From: Darryl Hobden [REDACTED]
Sent: 08 February 2018 11:33
To: Planning.Responses
Subject: RE: CM/33/17 Mill House Climping - Footpath 174

Darryl Hobden
Access Ranger – Area 4
Rights of Way - Highways and Transport
West Sussex County Council

Drawing No.	Drawing Title:
2	Site Plan

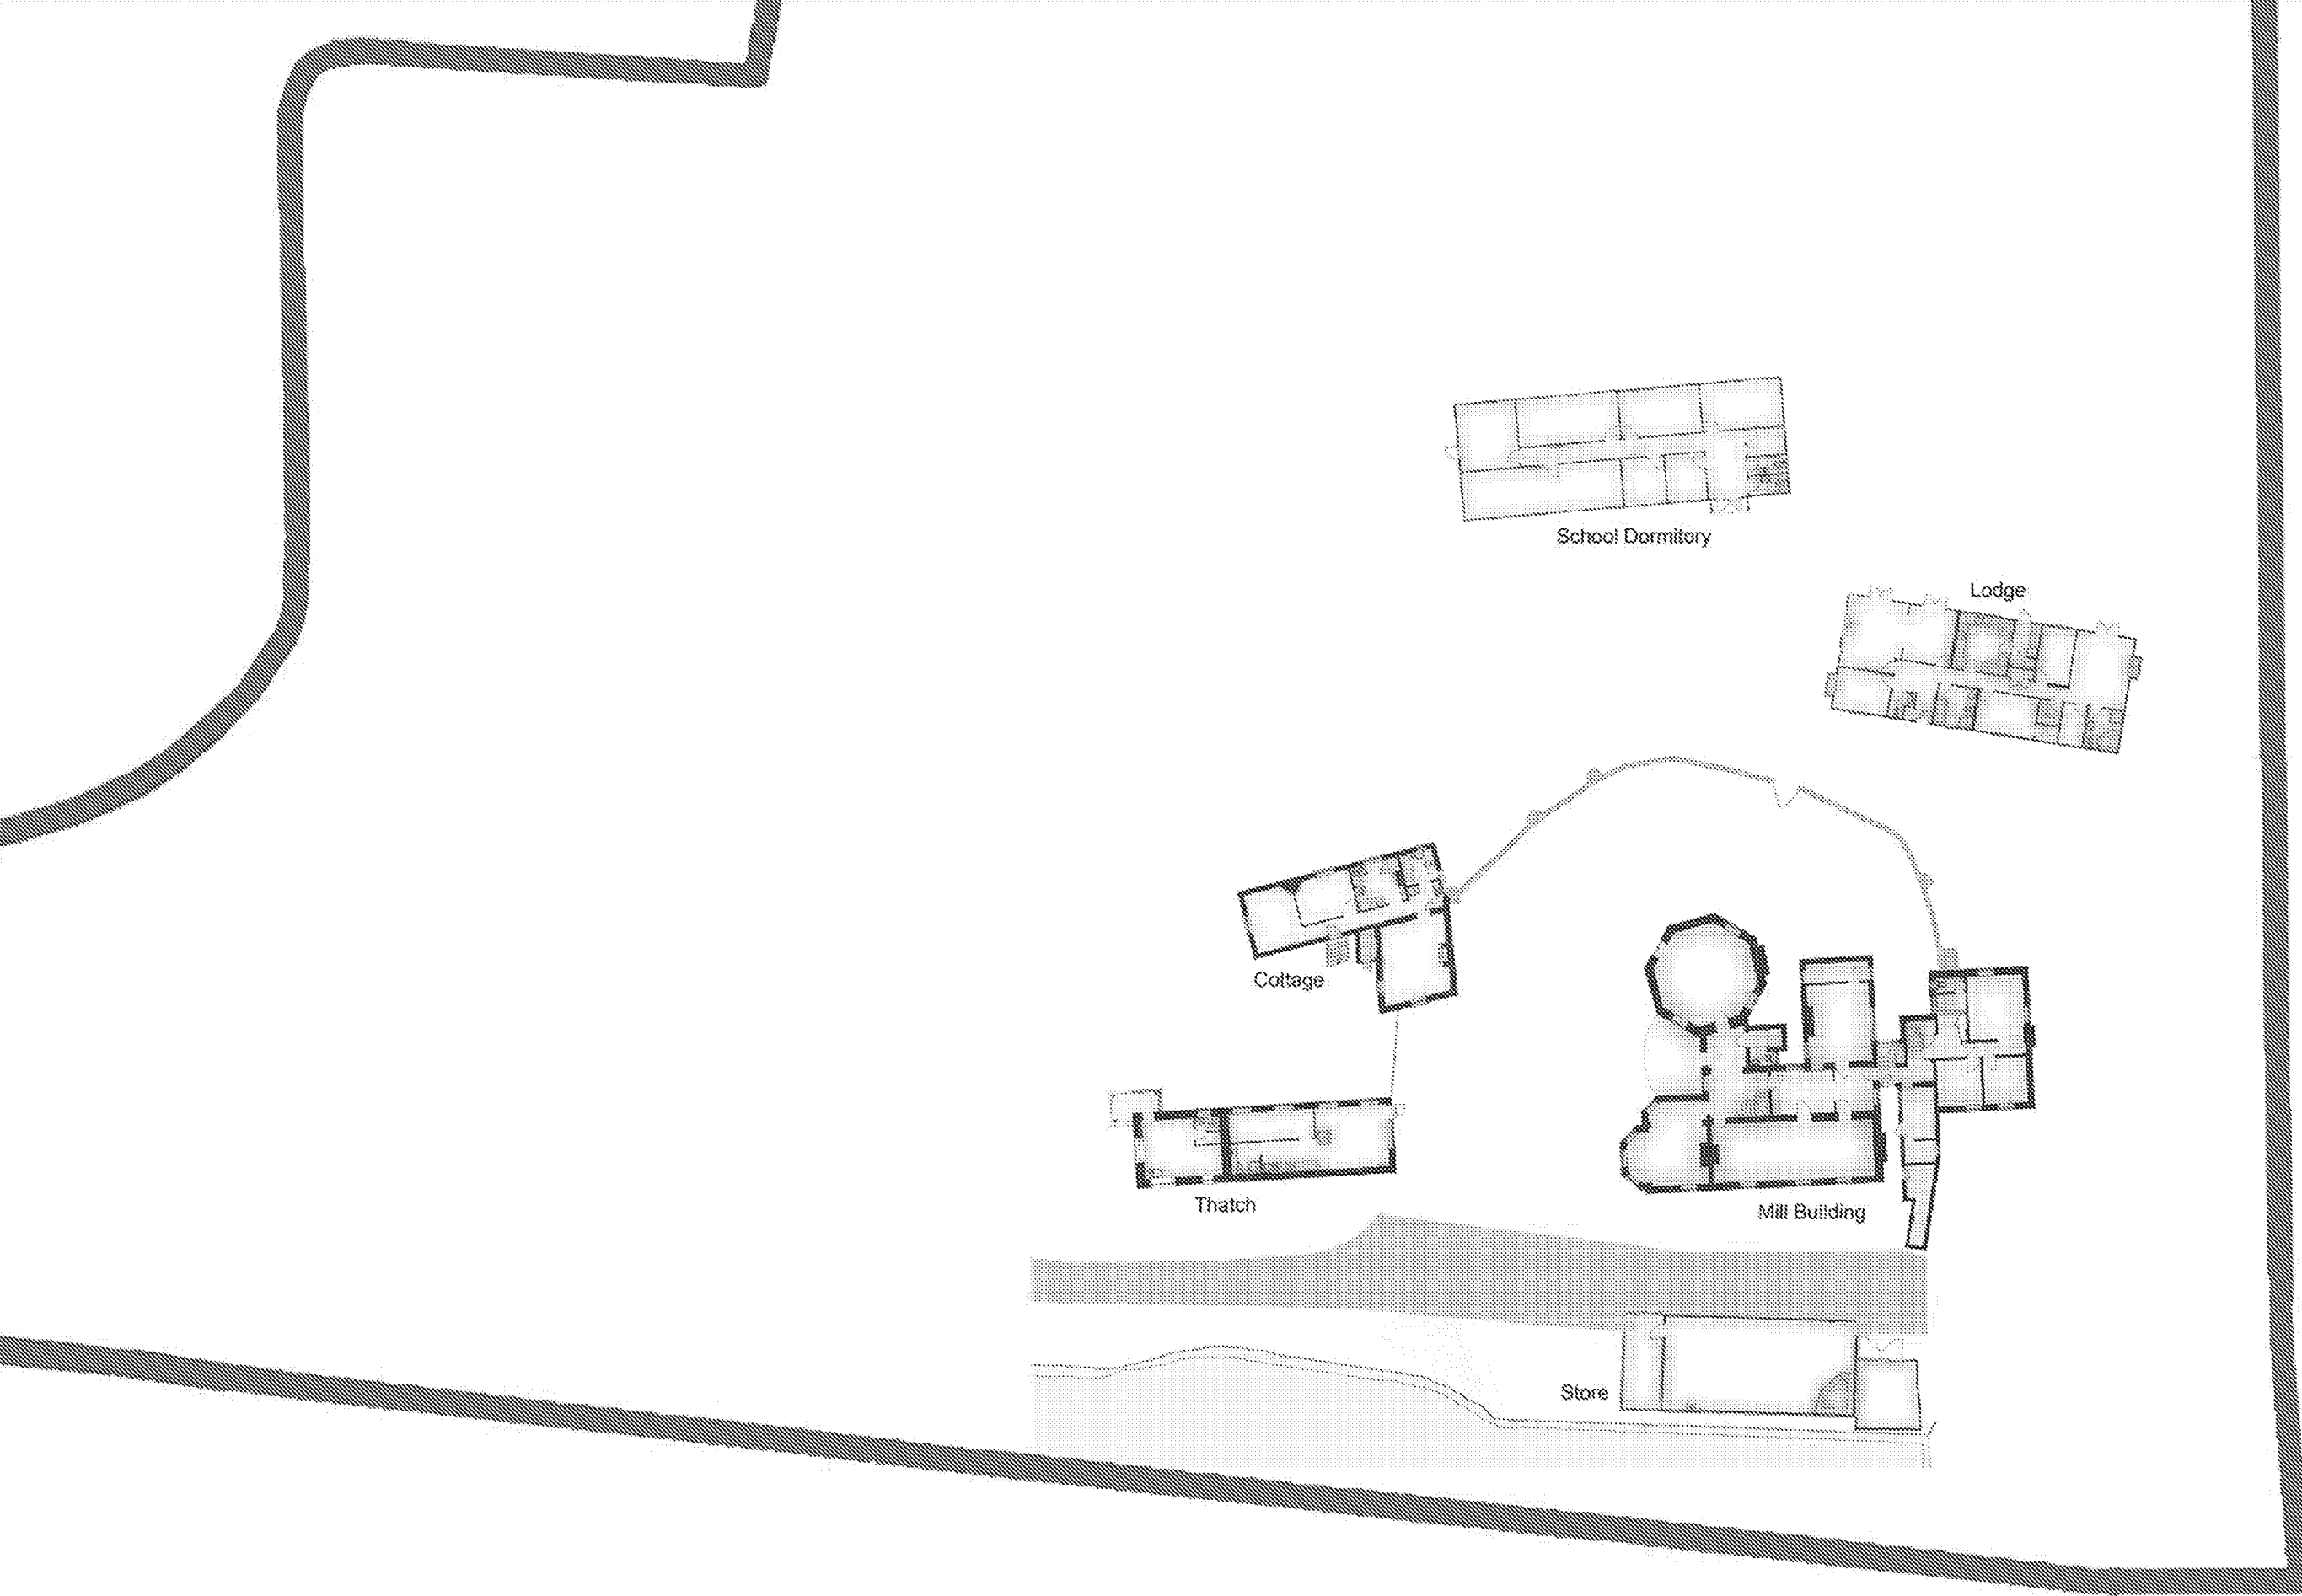
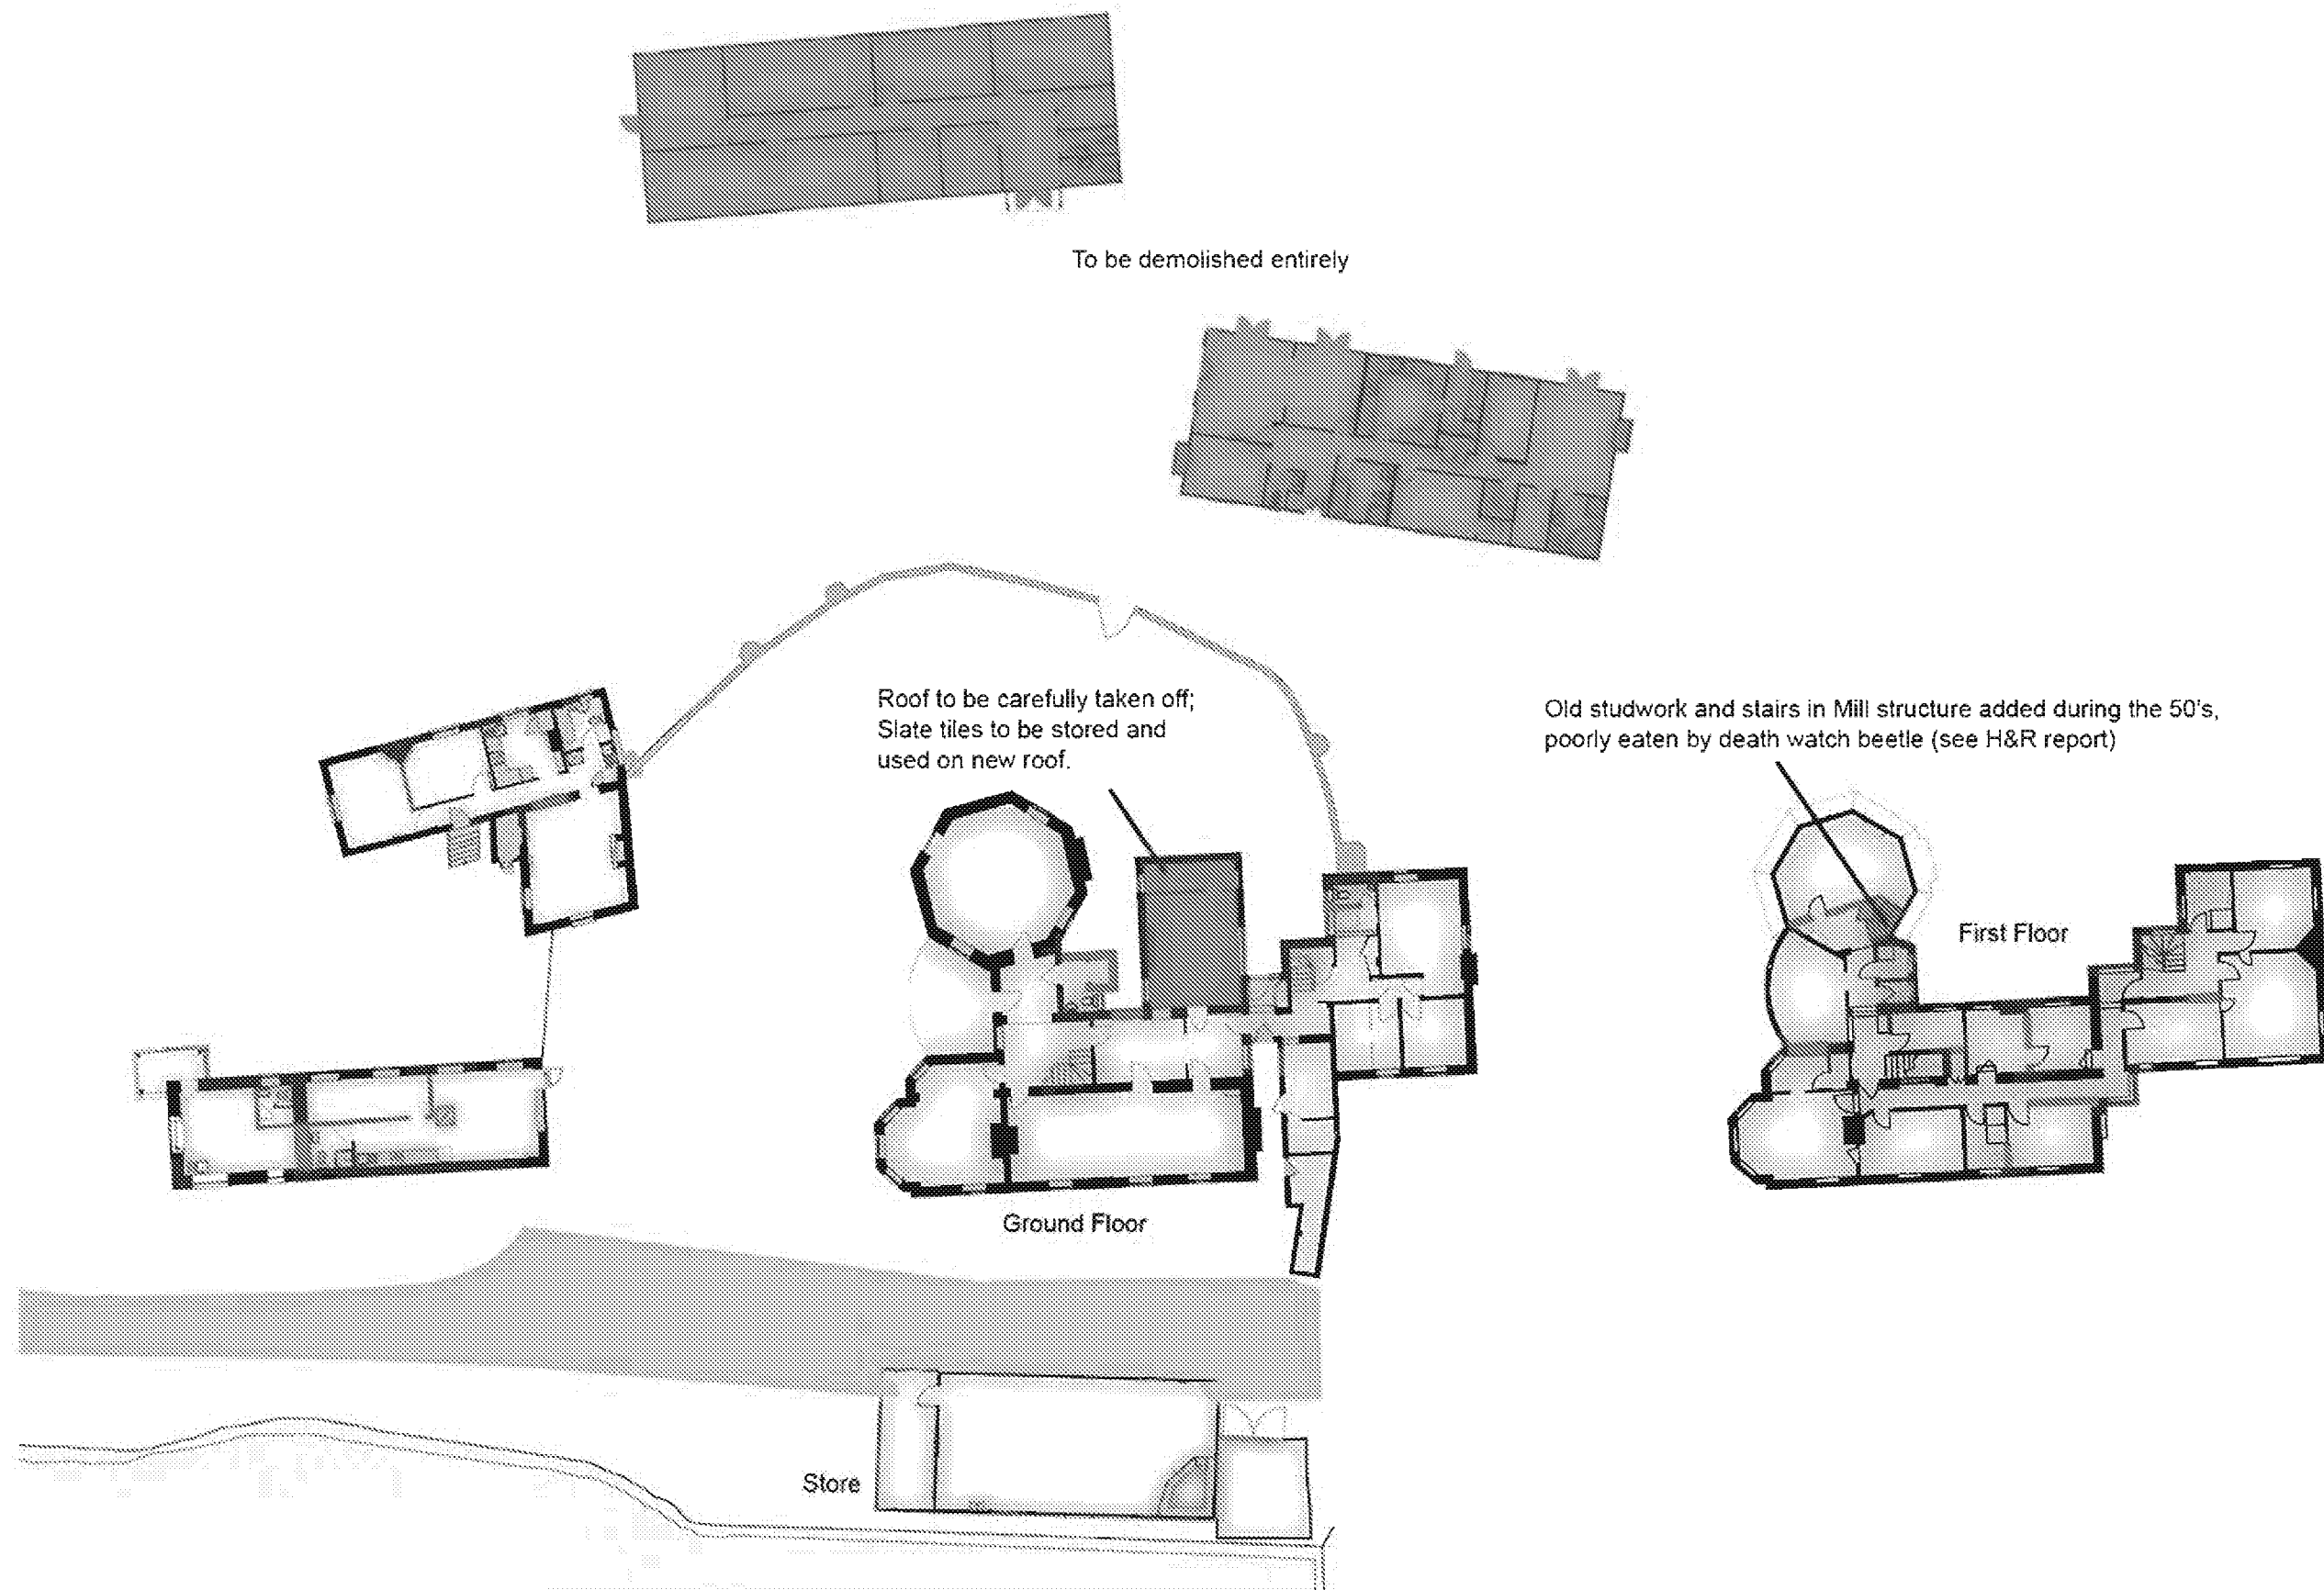
Due to the proposal to potentially build directly on the legal line of Public Footpath 174 a legal diversion Order will be required.

My concern is that development affecting the currently recorded legal line of the Public must not begin until and unless the path has been formally accommodated else an offence is being committed and may invalidate any diversion Order procedure.
